**From:** Sue Howell <[Sue.Howell@arun.gov.uk](mailto:Sue.Howell@arun.gov.uk)>  
**Sent:** 12 September 2019 16:14  
**To:** Michael Eastham <[Michael.Eastham@arun.gov.uk](mailto:Michael.Eastham@arun.gov.uk)>  
**Subject:** RE: LU.280.19.NMA - PLAN Kingley Gate

**Subject:** LU.280.19.NMA - PLAN Kingley Gate

Drawing No: 16.041.004

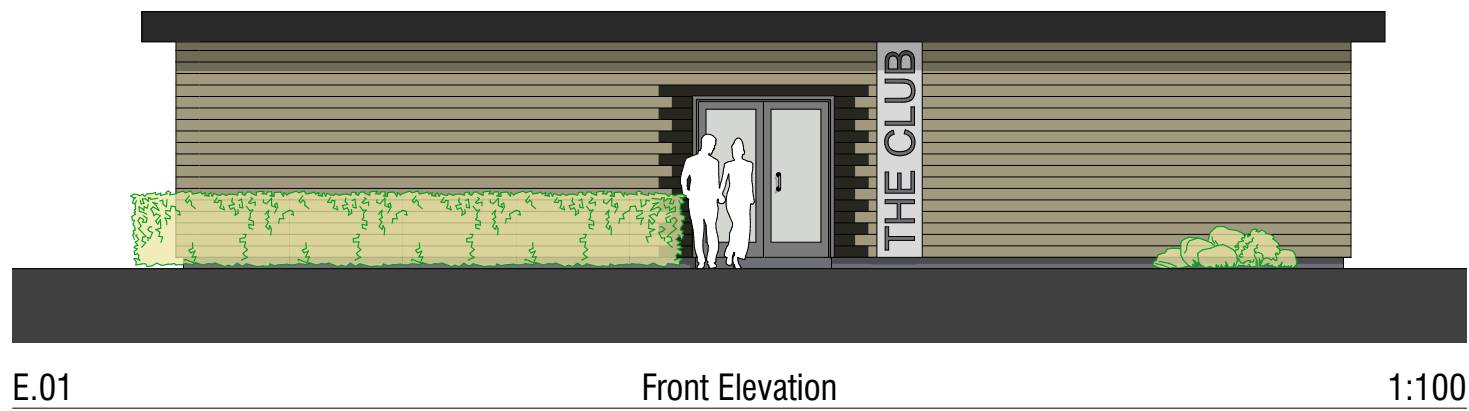
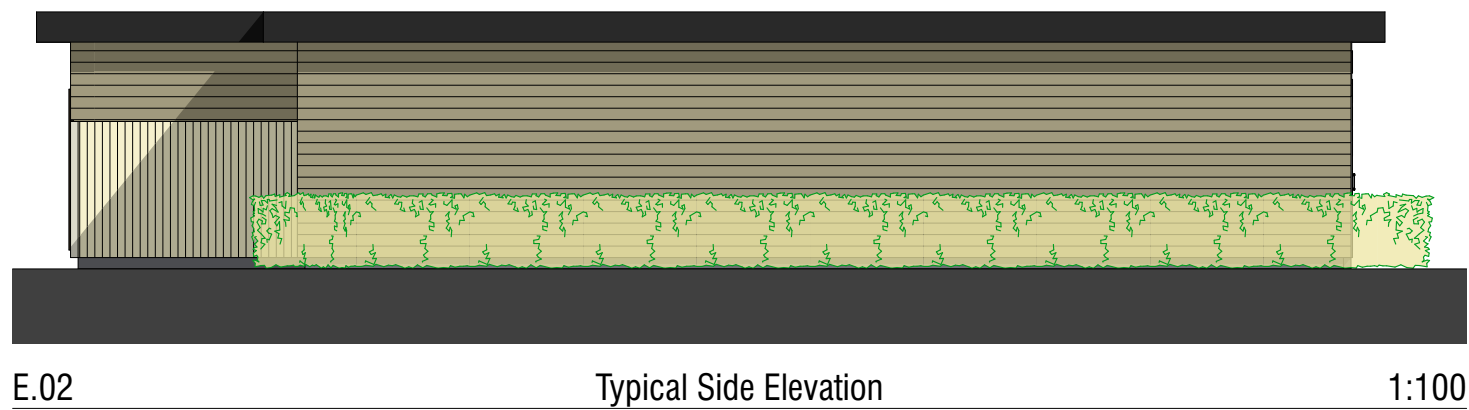
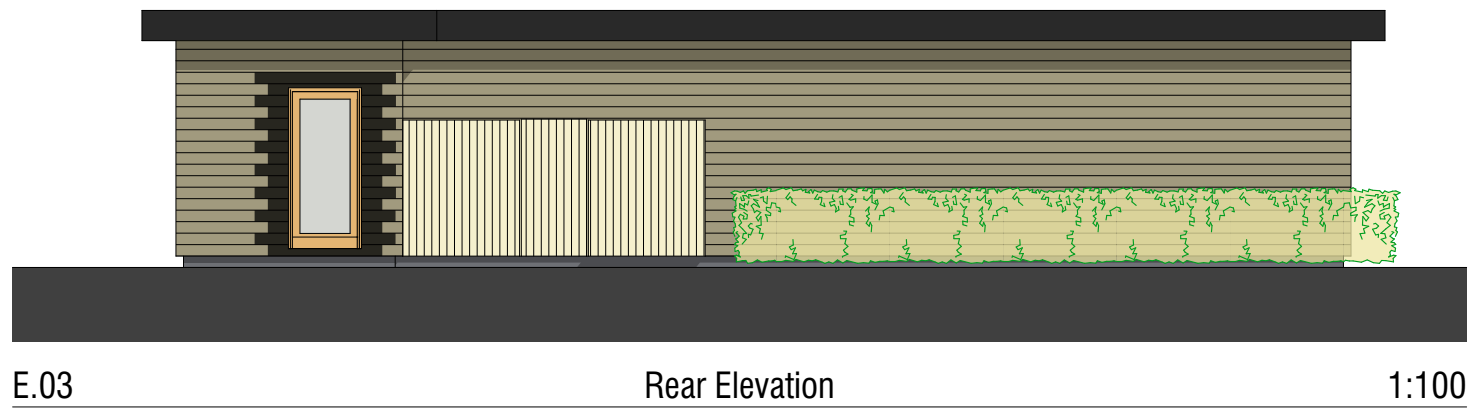
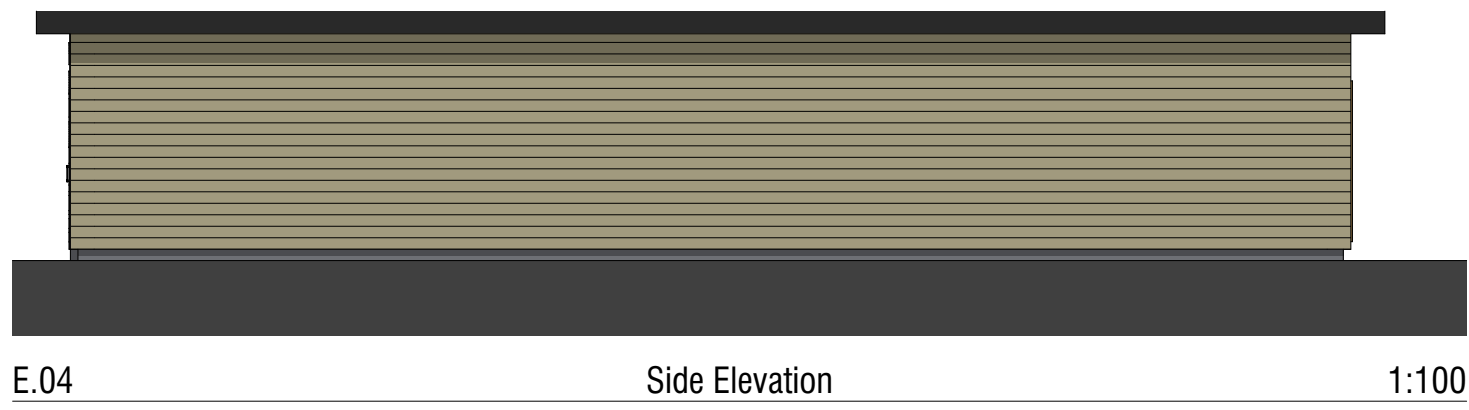
So it doesn't actually give any detail other than pictorial, but from your message I can say that assuming this is a Berberis hedge and is to match in with a further section in this location then yes it would be suitable for application.

Generally I would need to ask for plant spacing, quantities and size at time of planting.

We would like the berberis hedge to go around the timber enclosure, leaving a space for the door.
